Gatwick Airport Northern Runway
National Infrastructure Project
TR020005

Relevant Representation Submission

27th October 2023

Drawn date:
September 2023

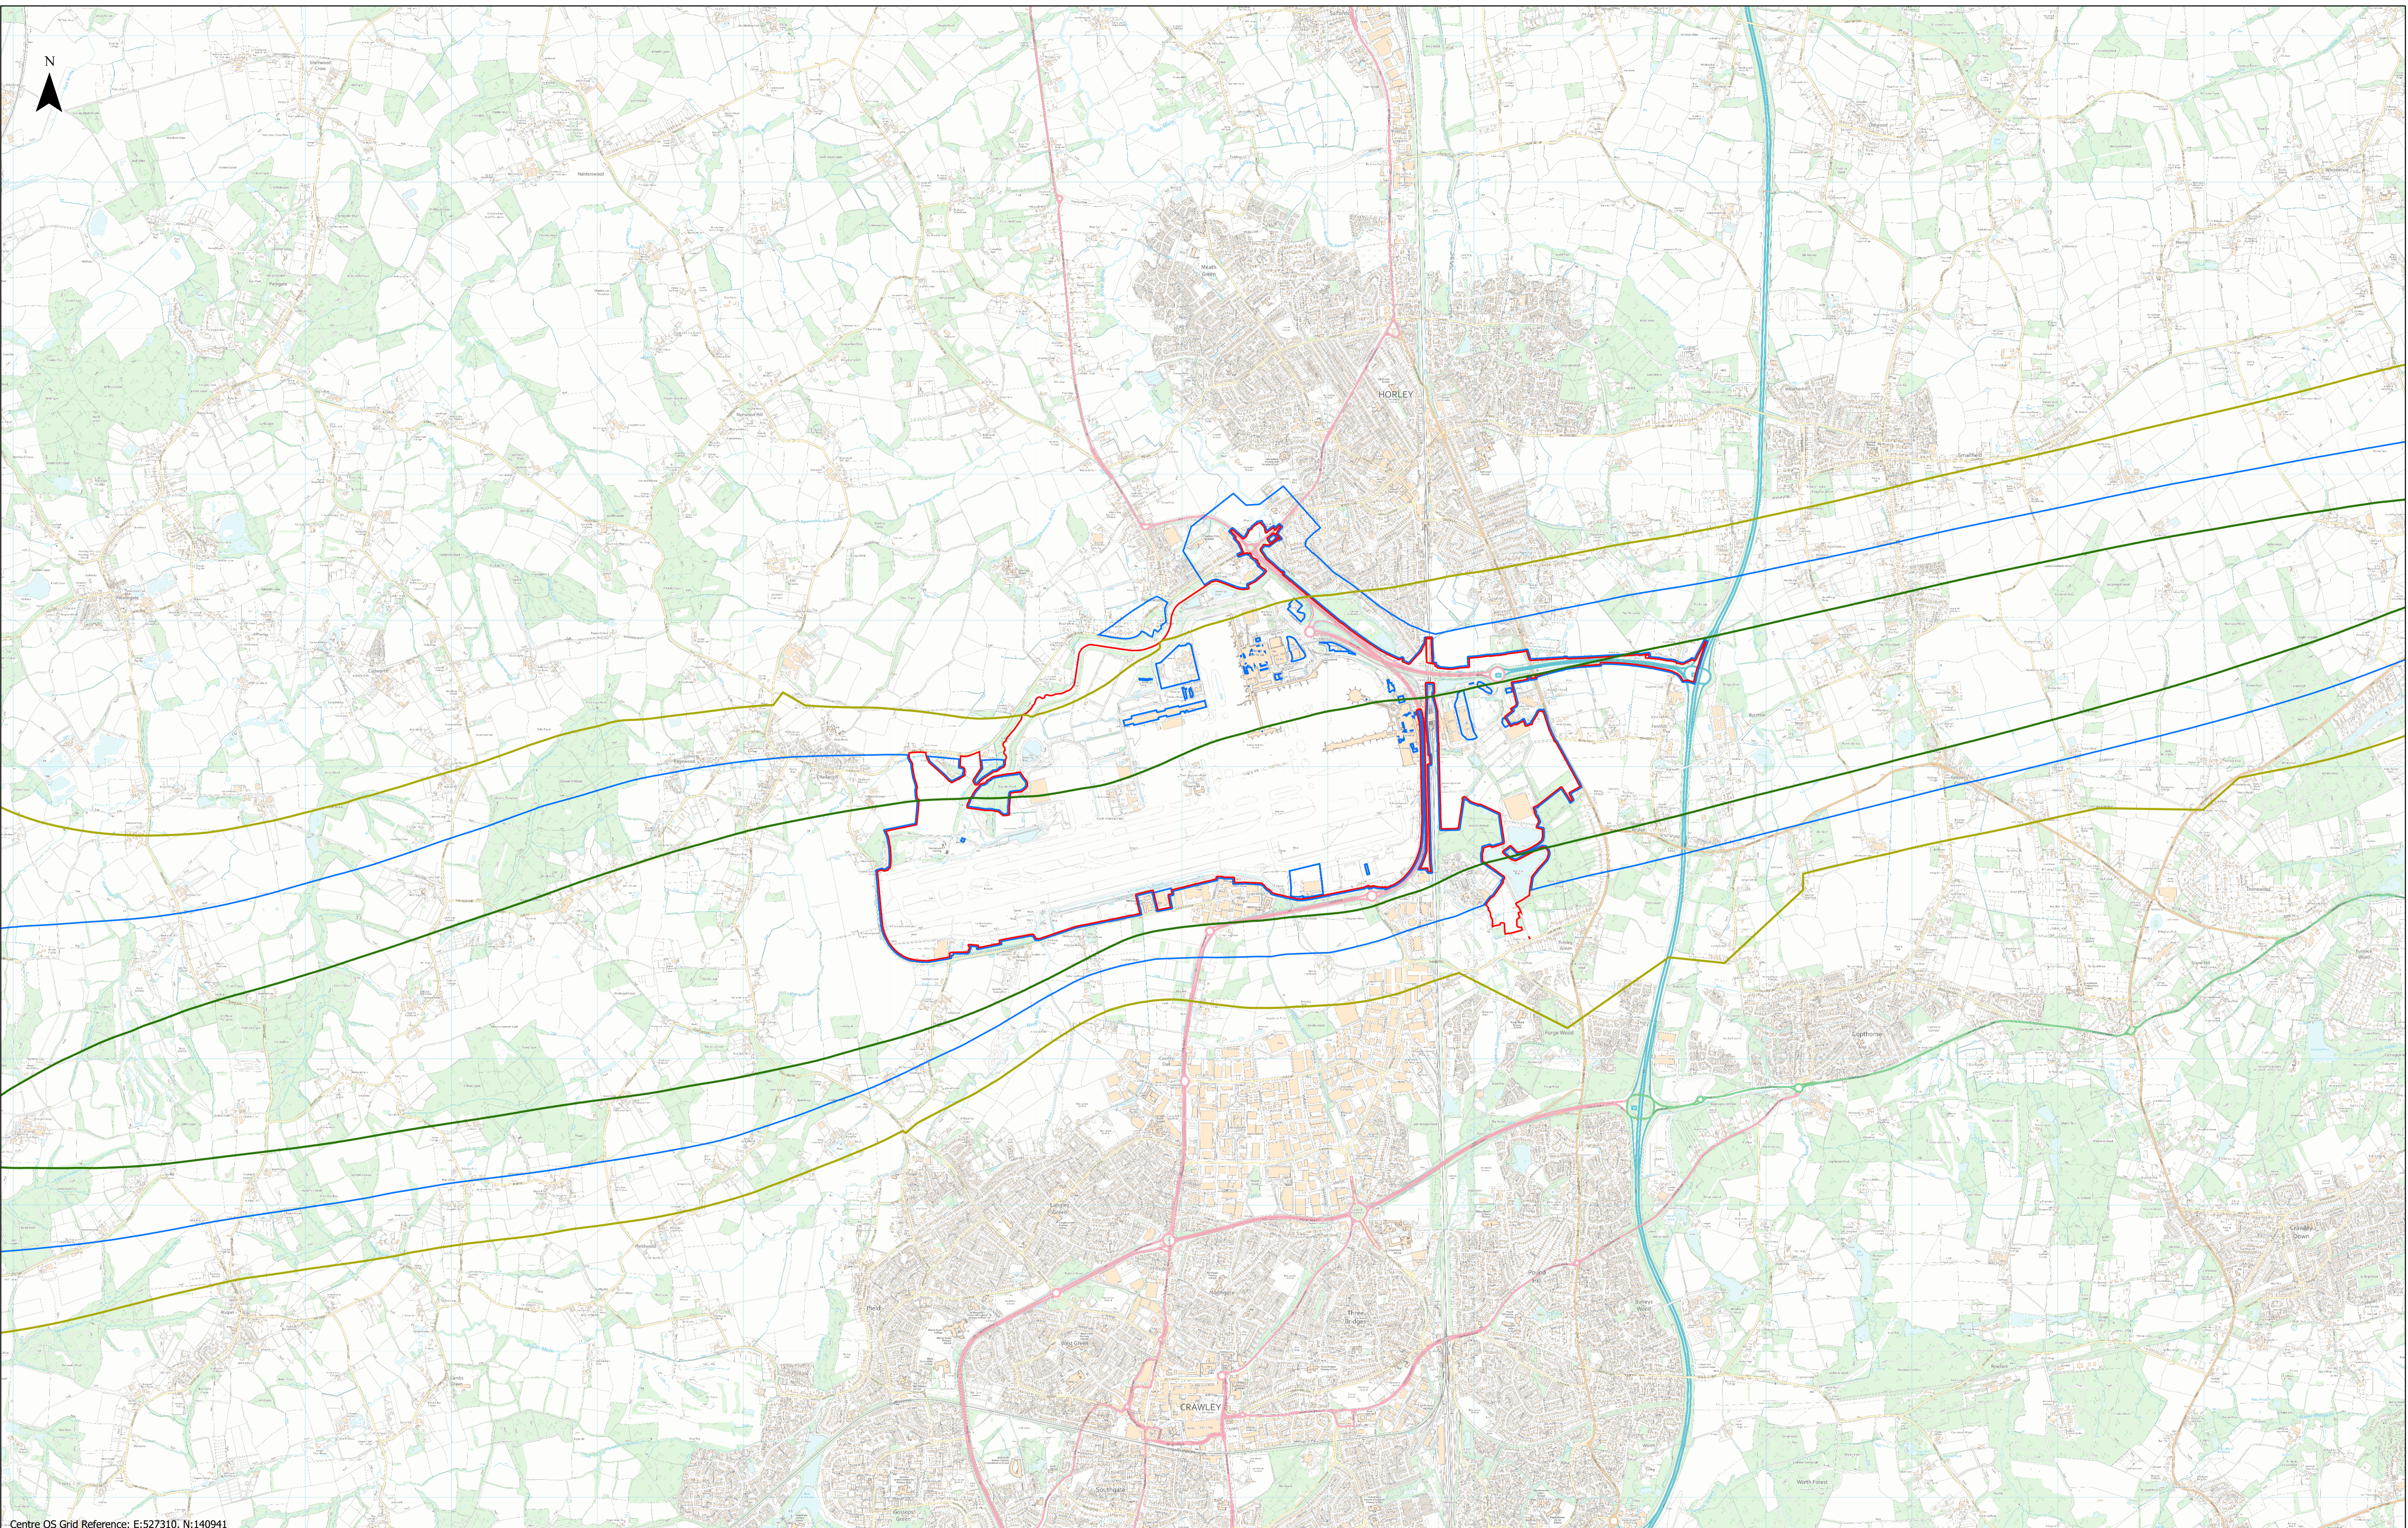
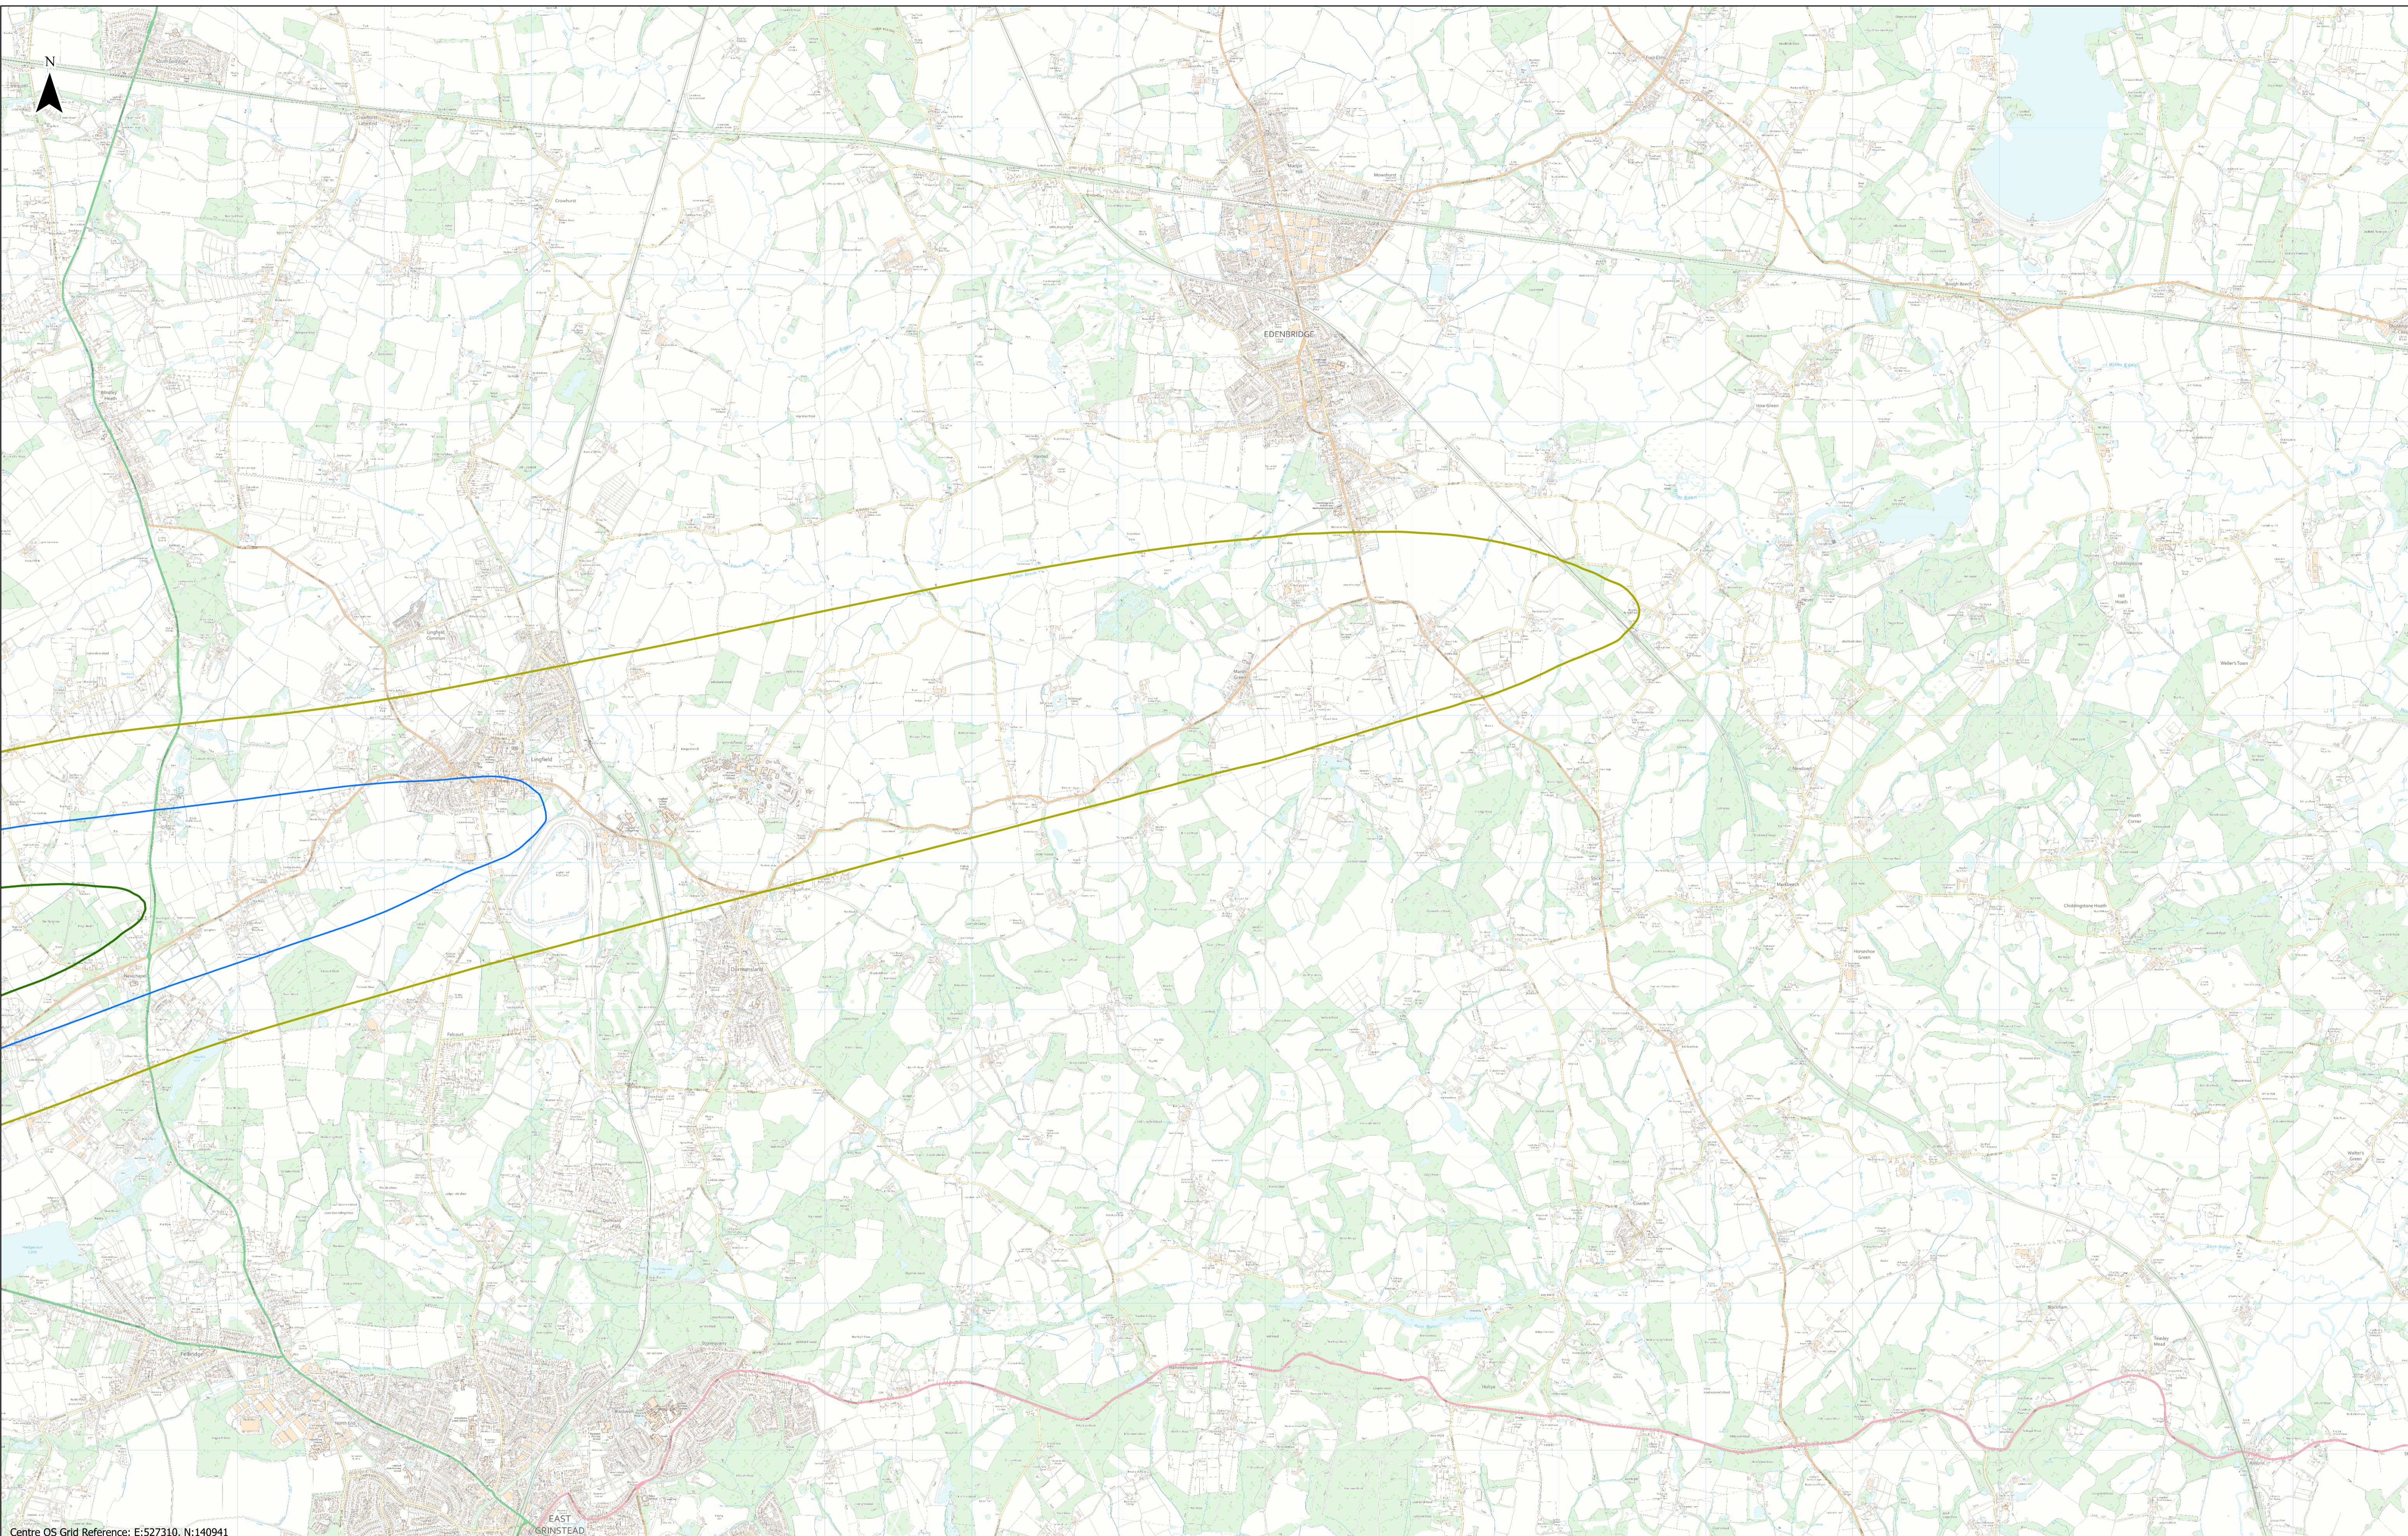
- a. Residents of properties within the inner zone will be notified within 6 months of commencement of works; however, the noise contours on which eligibility would be based upon are not clear.
- b. Residents in the outer zone should be offered more flexibility on the type of insulation rather than being restricted to ventilation.
- c. The noise insulation scheme should extend to community buildings (e.g. care homes, places of worship, village halls, hospitals etc.).

- d. It is not clear if properties that have already received insulation would be eligible for upgraded noise insulation as part of the new scheme.
- e. No details are provided on how monitoring of ground noise would be undertaken and how a property would be identified as appropriate for monitoring ground noise.
